REVISION/DEFERRED SUBMITTAL FORM

Site Address 6215 86th Ave SE Mercer Island, WA 98040 Permit Number 2103-070

Description of revision:

Relocation of kitchen from approved permit location. No structural modifications

A 3.01
CONSTRUCTION PLAN

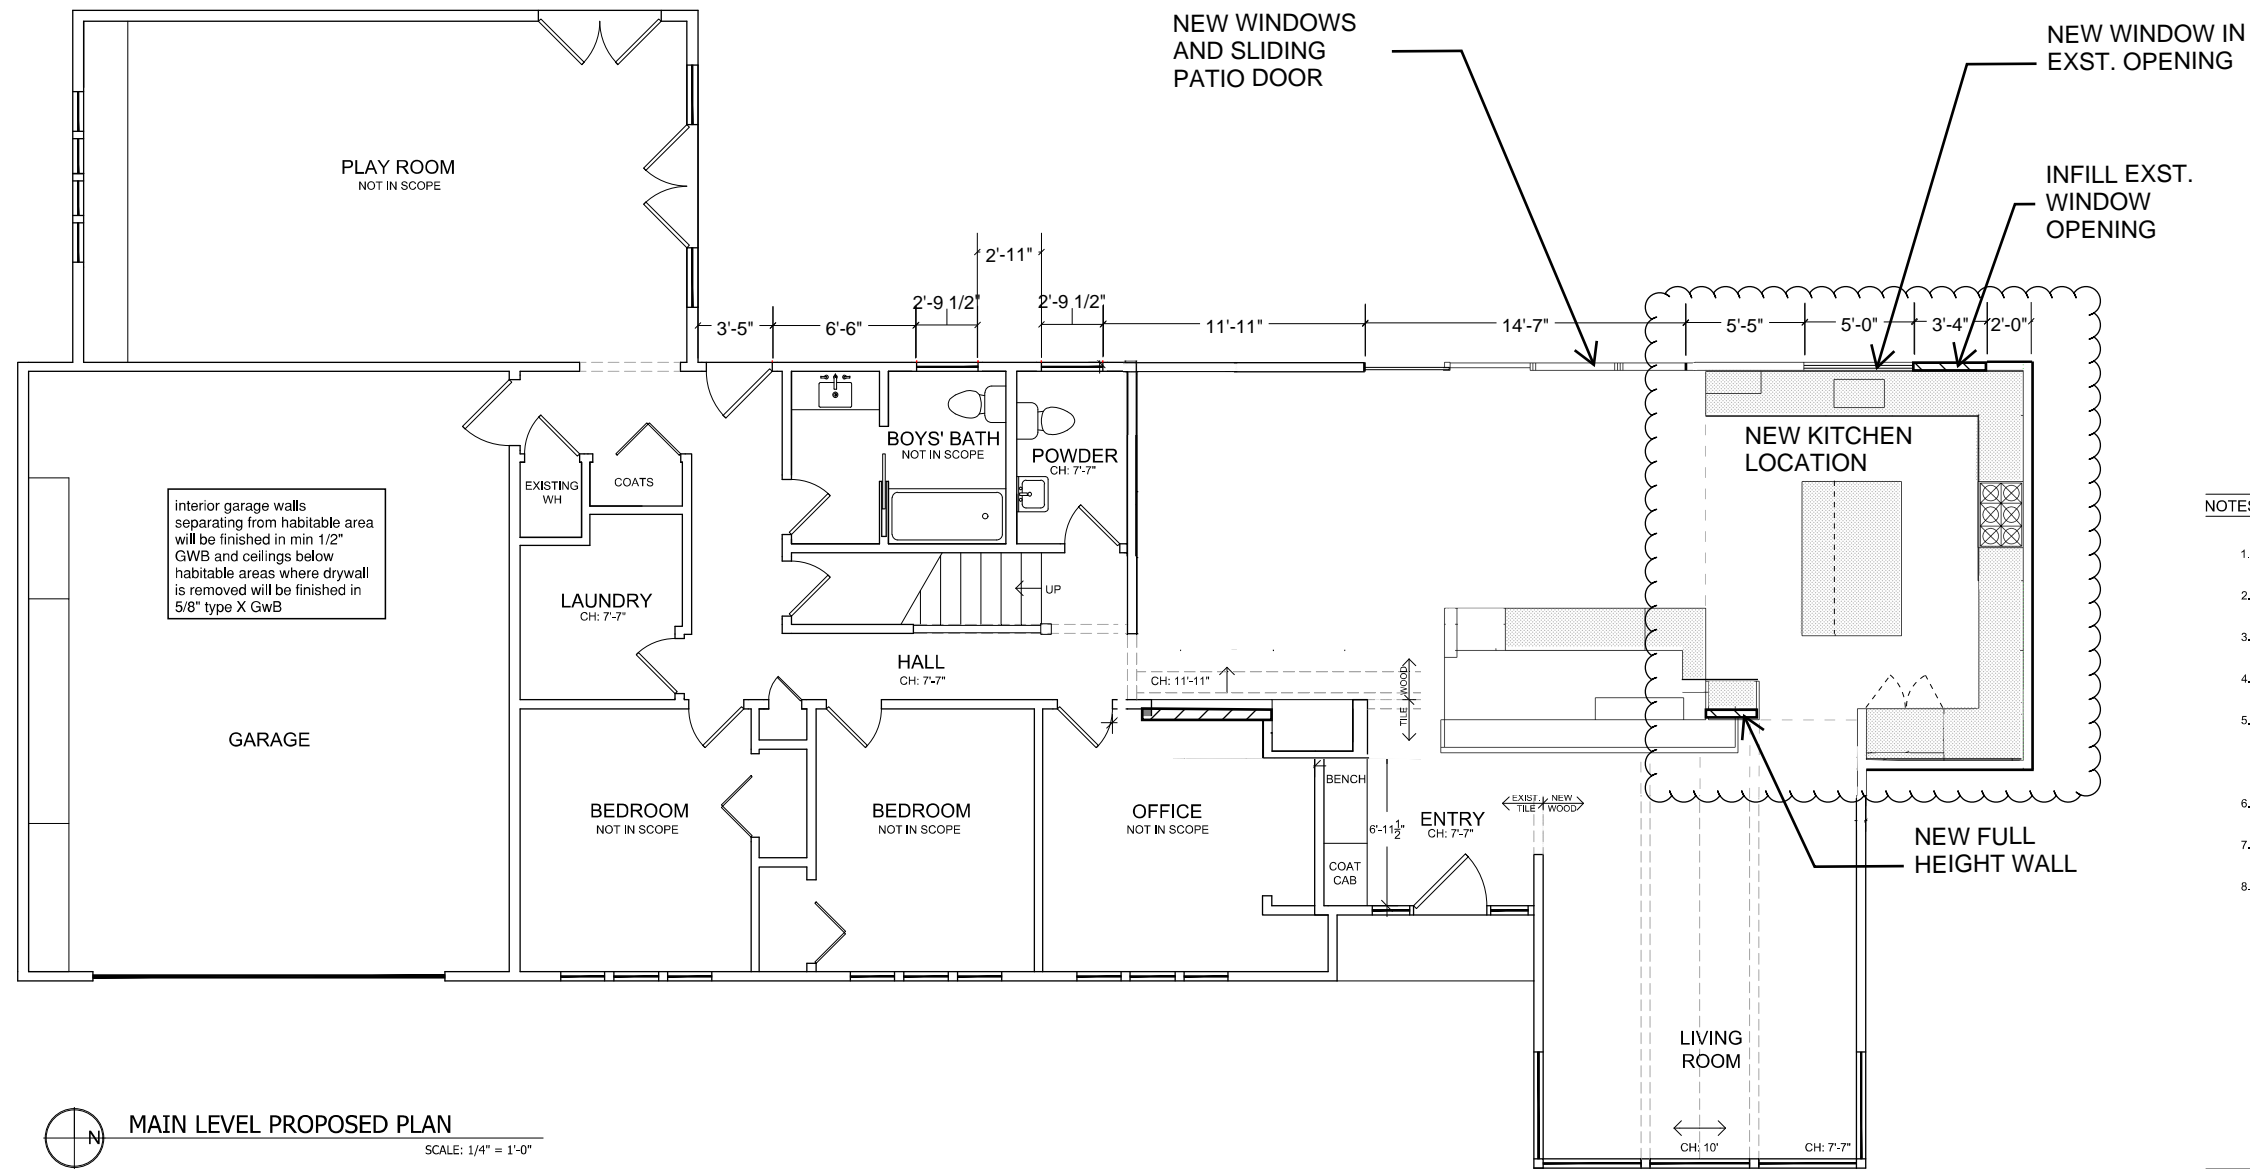
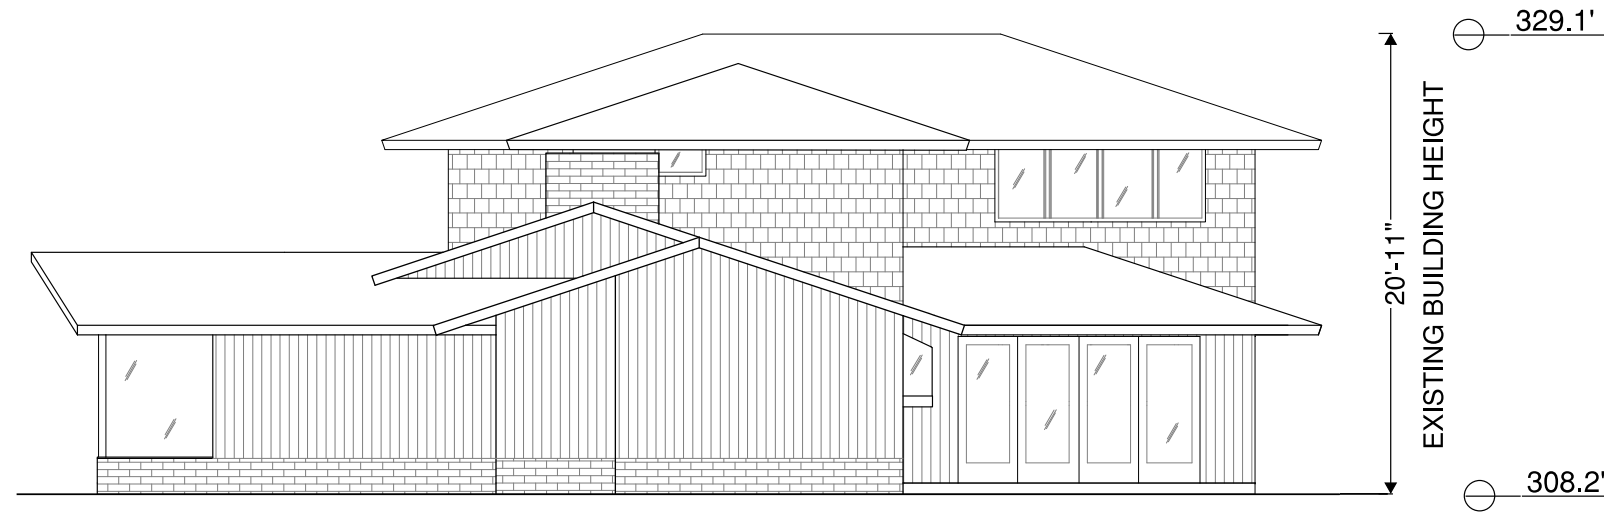
Sheet #	A 3.01	Kitchen relocated to north end of house
Sheet #	A 3.11	Existing window reduced in size. Kitchen window from approved permit removed
Sheet #		
Sheet #		
Sheet #		
Sheet #		
Sheet #		
Sheet #		
Sheet #		
Sheet #		
Sheet #		
Sheet #		
Sheet #		
Sheet #
